PLANNING AMENDMENT

APPLICANT NAME AND ADDRESS Mr + Mrs. J. Depeur. Northolme North Road Gedney Hill Lines PERZONS Telephone:		AGENT NAME AND ADDRESS G.R. Merchant Ltd. 4 Wrights Mews 12A Park Road Holbeach PERZEE Telephone: 01406 490800.	
SITE ADDRESS DETAILS The Pipers, 164 North Road, Gedney Hill Lines PERZONS.			
CURRENT APPLICATION NO: This amendment cannot be considered unless the relevant reference is stated.		H07-0081-15.	
Building Regulation reference relating to same development (if applicable)		—

Description: Extension & Alterations

Location: The Poplars
164 North Road
Gedney Hill
Spalding
PE12 0NS
PE12 0NS

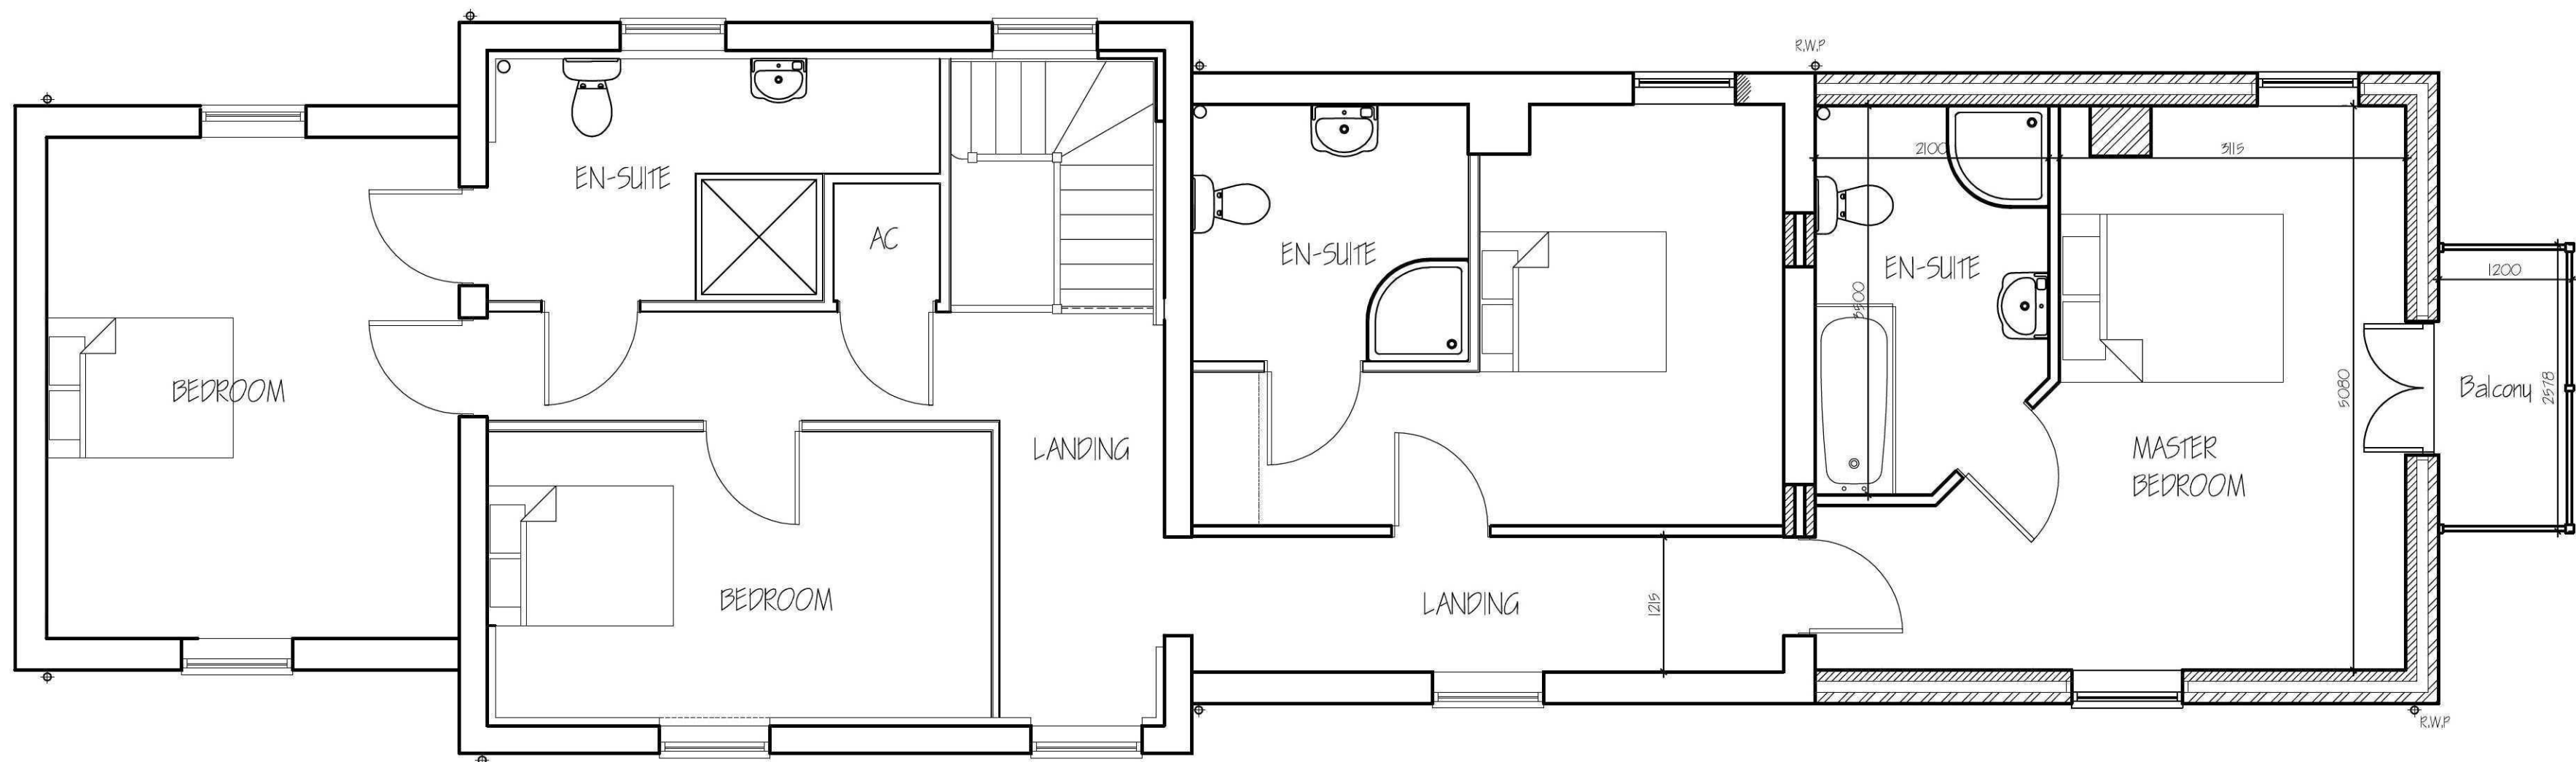
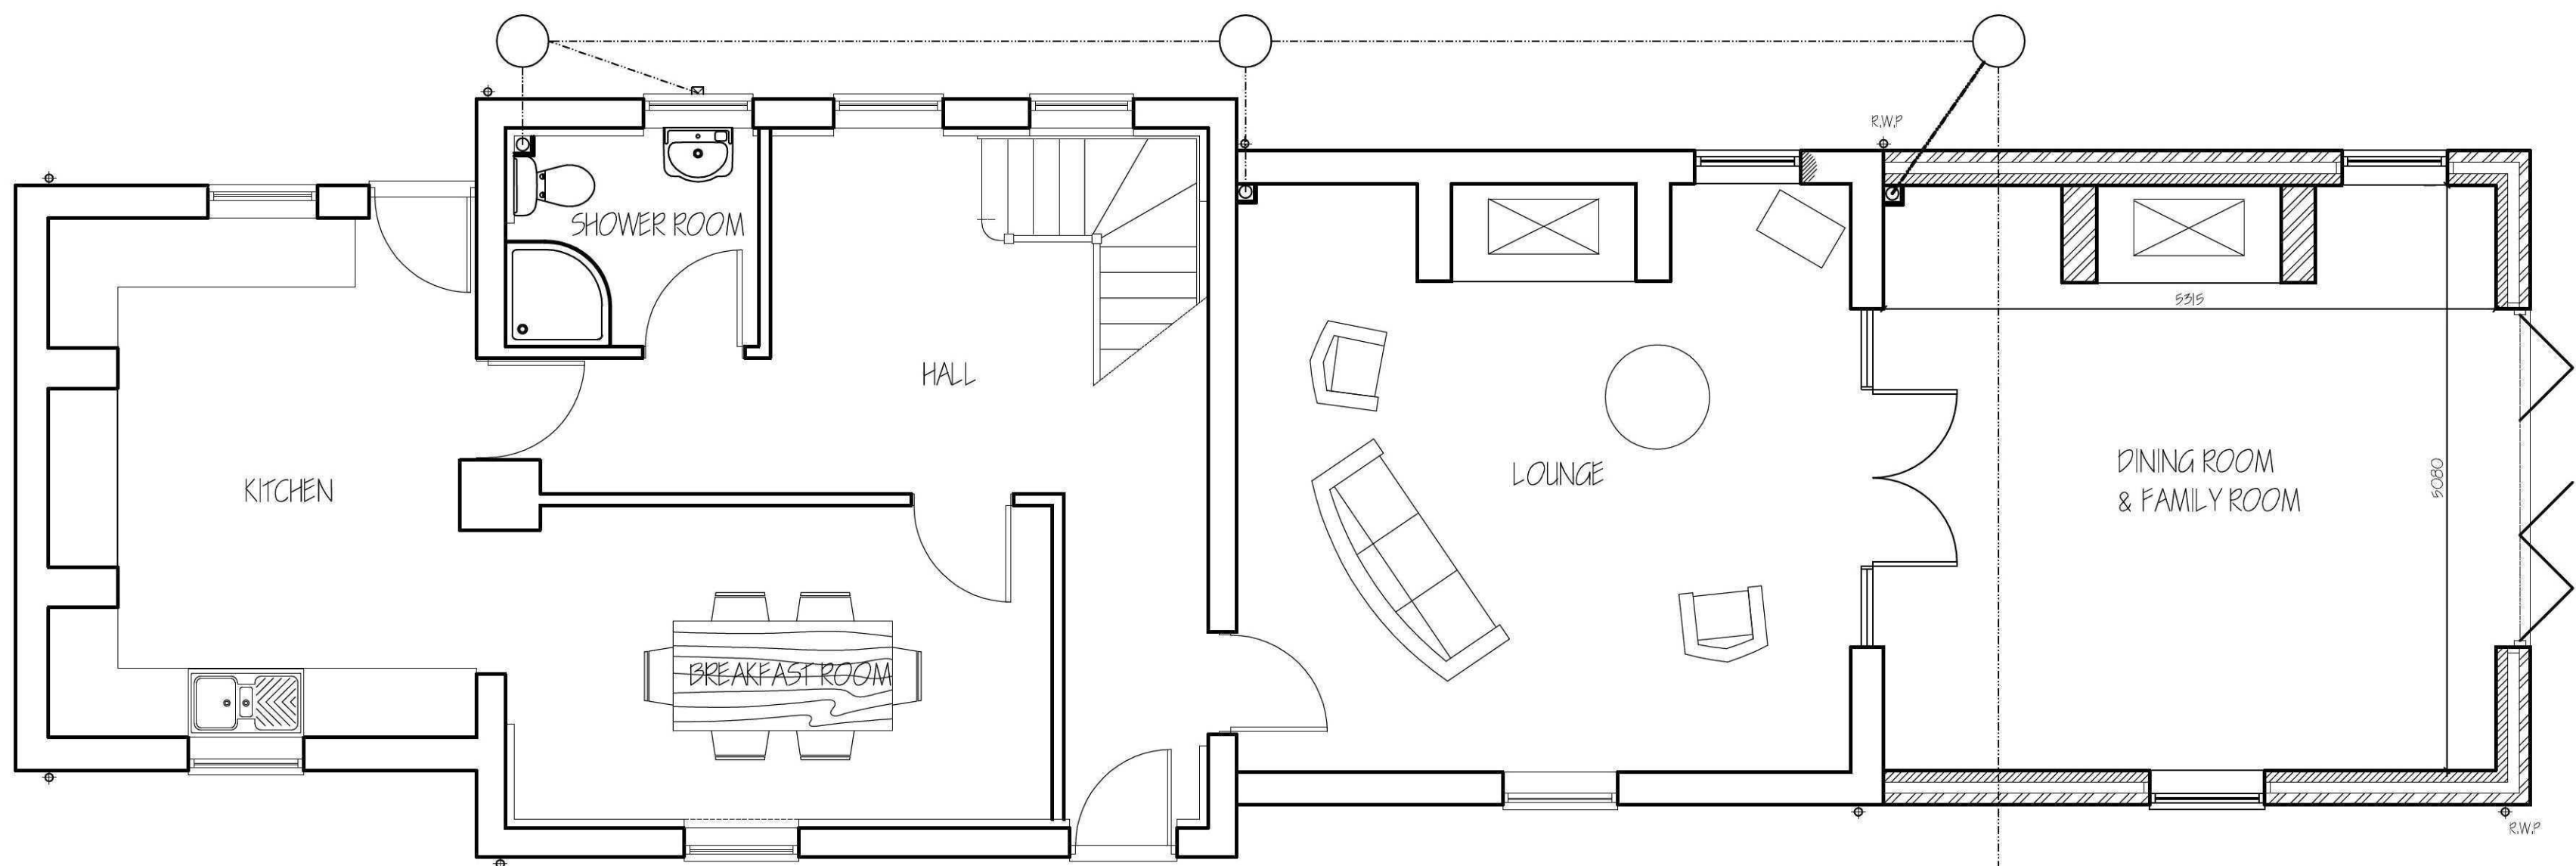
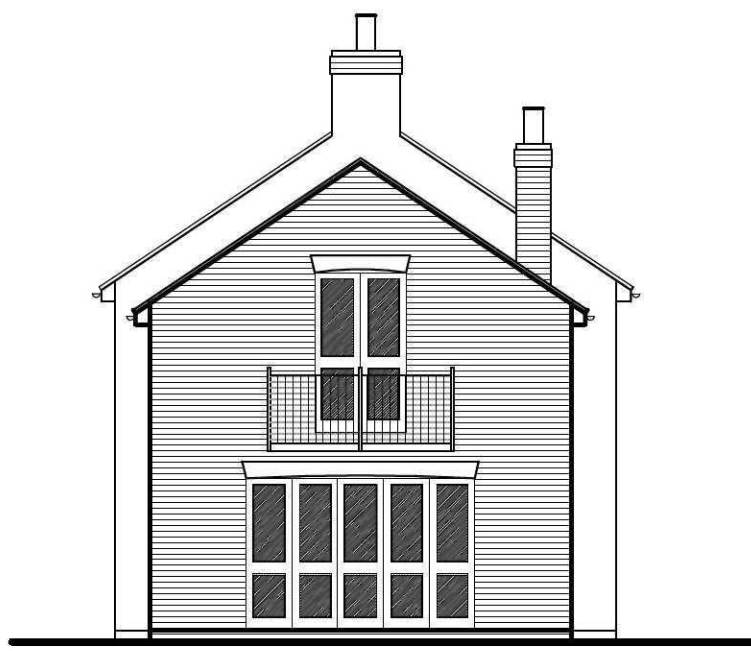
Amendment: Chimney and log burning stove added to extension
(Dwg no. 2745-15-02A)
